Planning Application Ref: **FG/178/18/DOC**

Location: **Ferringham House, 58 Ferringham Lane, Ferring BN12 5LU**

Description of works: **Approval of details reserved by condition imposed under FG/27/18/PL relating to conditions 7-Construction Management Plan & 10-protection of retained trees**

Drg No  
**NJCL 214 B-2**

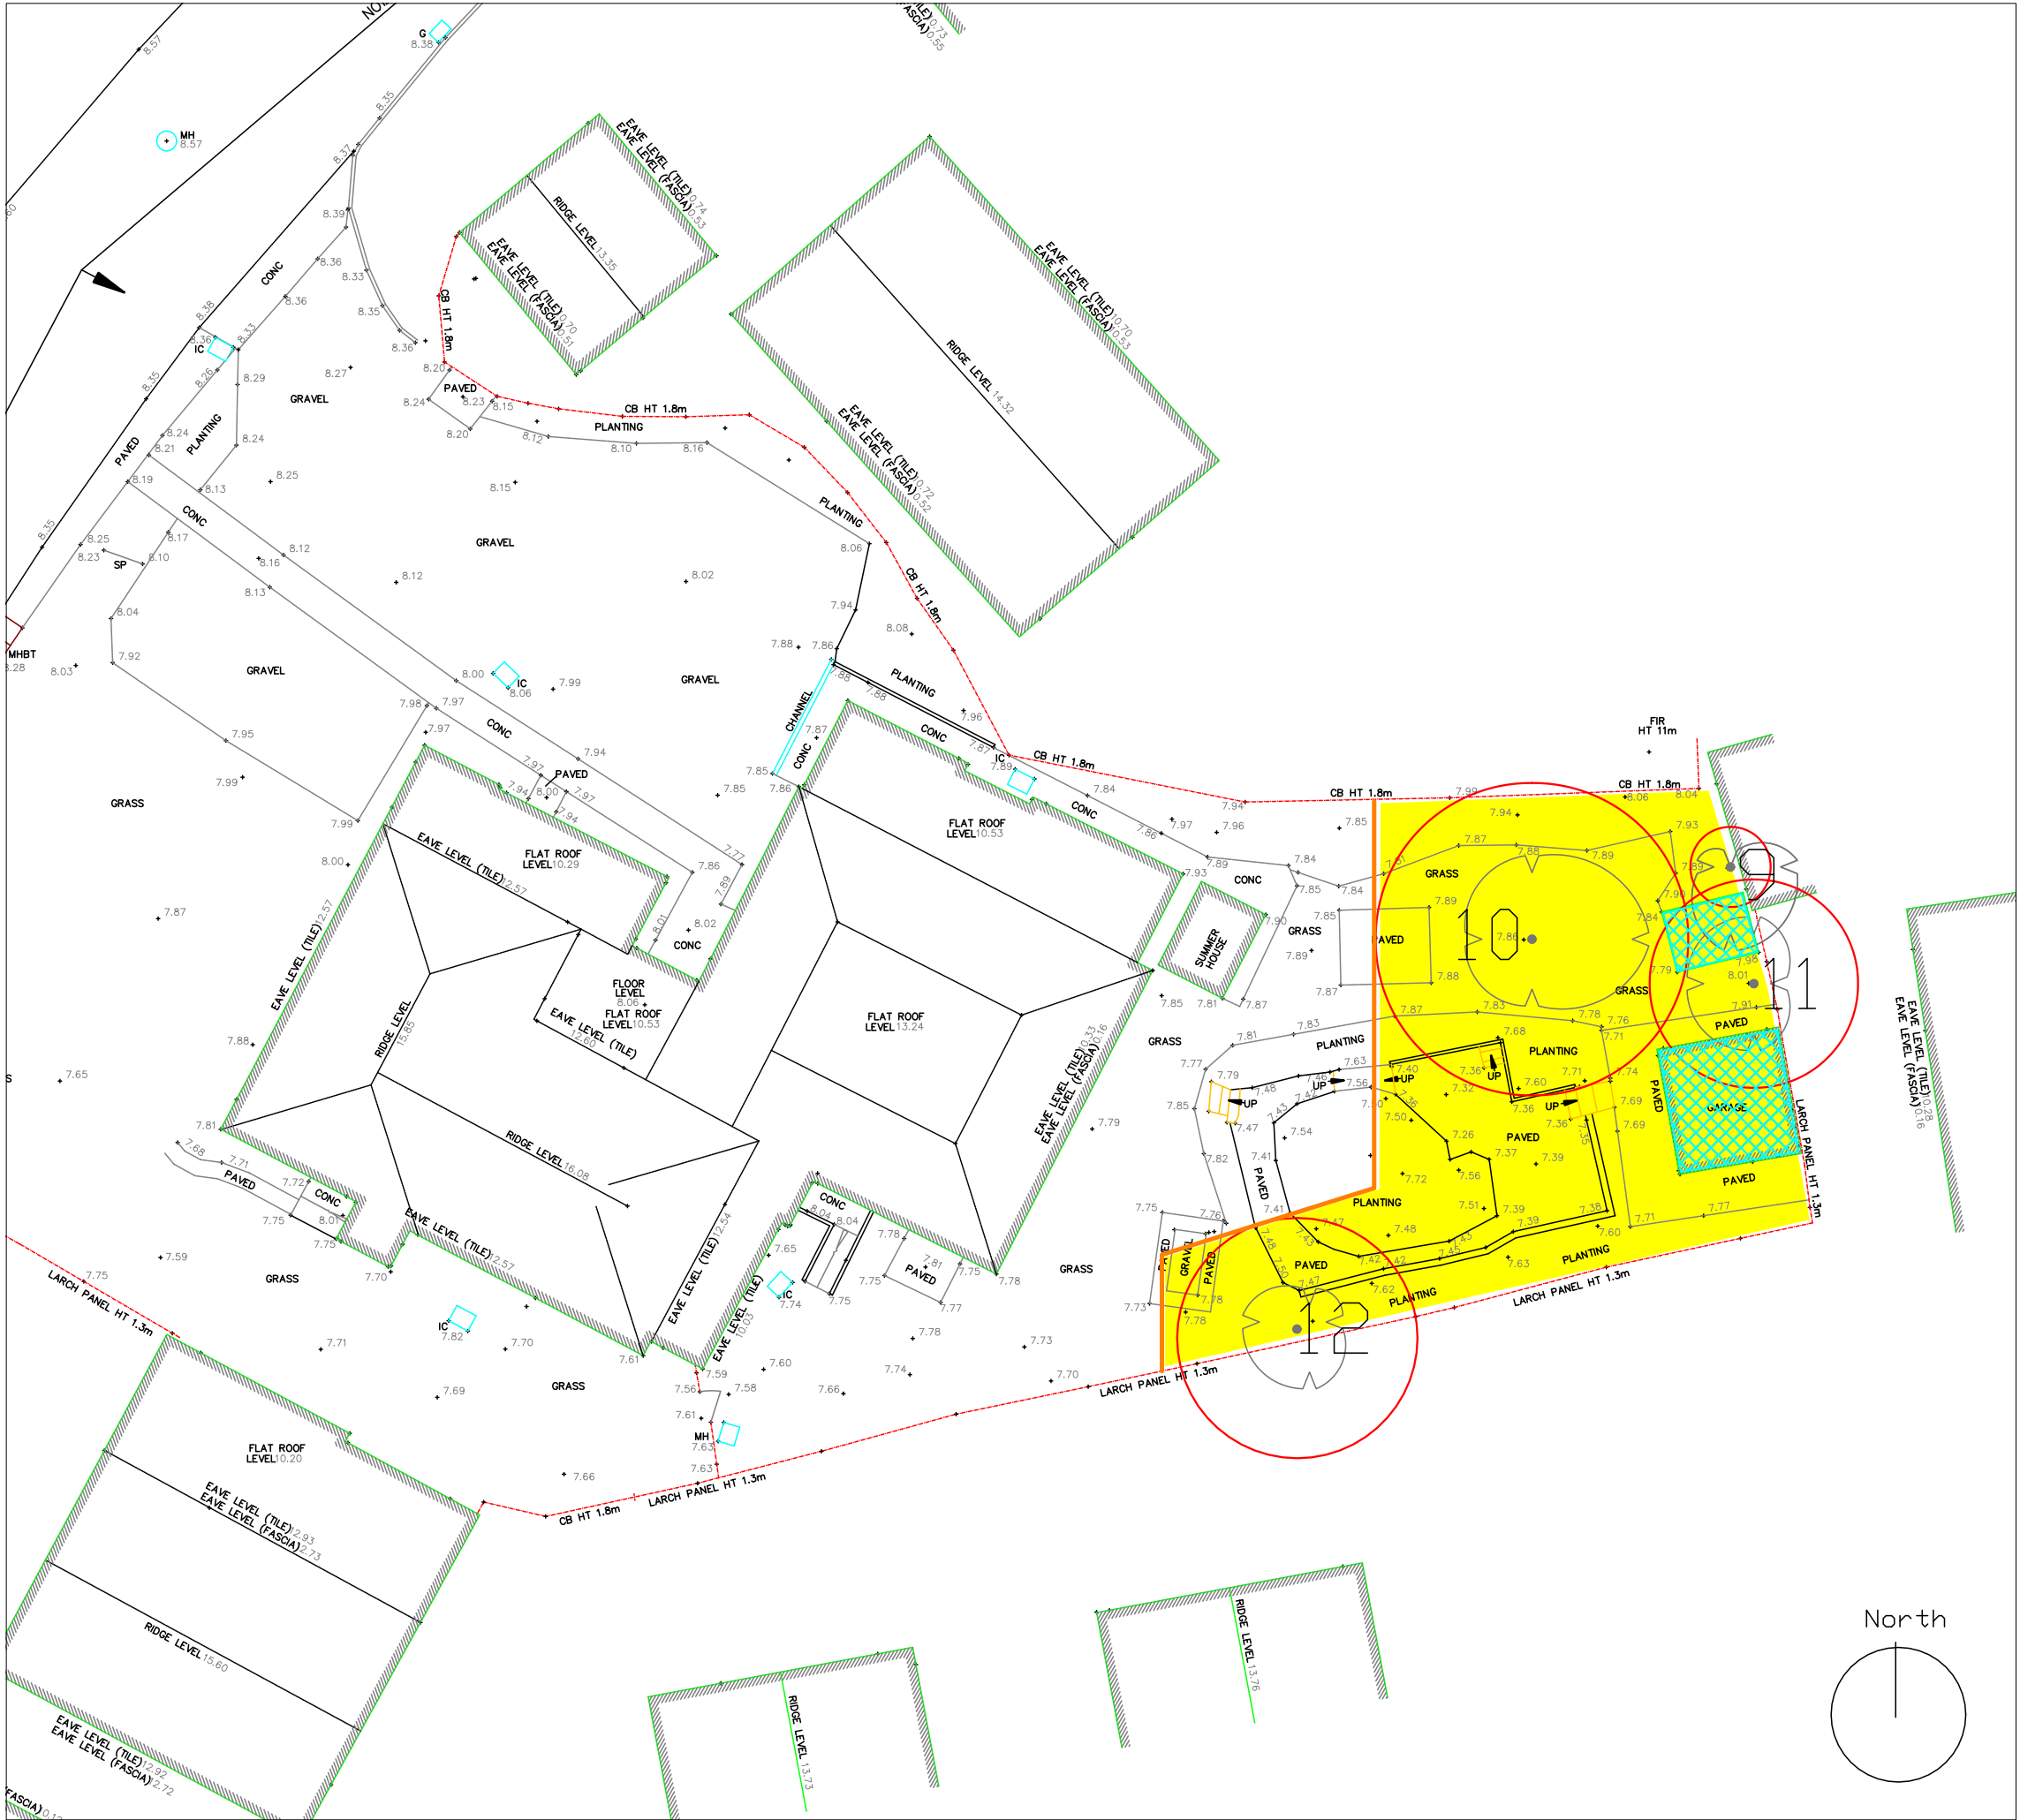
- I visited the site earlier today. I had the following Tree Protection Plan to refer to:
 - Drawing No. NJCL 214 B-2, dated 19.09.2018, from Nicholas Jones Consultants Ltd., submitted in support of FG/27/18/PL
- The above plan shows the position of 'fit for purpose' fencing to effectively form a construction exclusion zone around significant retained trees, as is standard practice and required by BS5837.
- None of the aforementioned fencing has been installed or even brought to site at this time. I attach photographs taken at the time of my inspection.

- The provision (and subsequent agreement by the LPA) of a suitable Tree Protection Plan (TPP) is not of itself sufficient to discharge the condition. This has always been MY approach and one I am familiar with having been followed by experienced practitioners of BS5837:2012.

- Any tree protection measures must be in place before heavy plant access, soil movement, demolition or construction occurs. The prior installation of an effective 'Construction Exclusion Zone' must be inspected by and be to the satisfaction of the LPA (Tree Officer) before the relevant condition can be discharged. Anything less and we are facilitating the occurrence of potentially irreversible damage to those trees identified for retention.

- The developer must now install the fencing in accordance with the Tree Protection Plan to form an effective Construction Exclusion Zone; so as to adequately respect and protect significant trees before any work occurs.
- As things stand, **I am unable to recommend 'signing off' on Condition 10.**
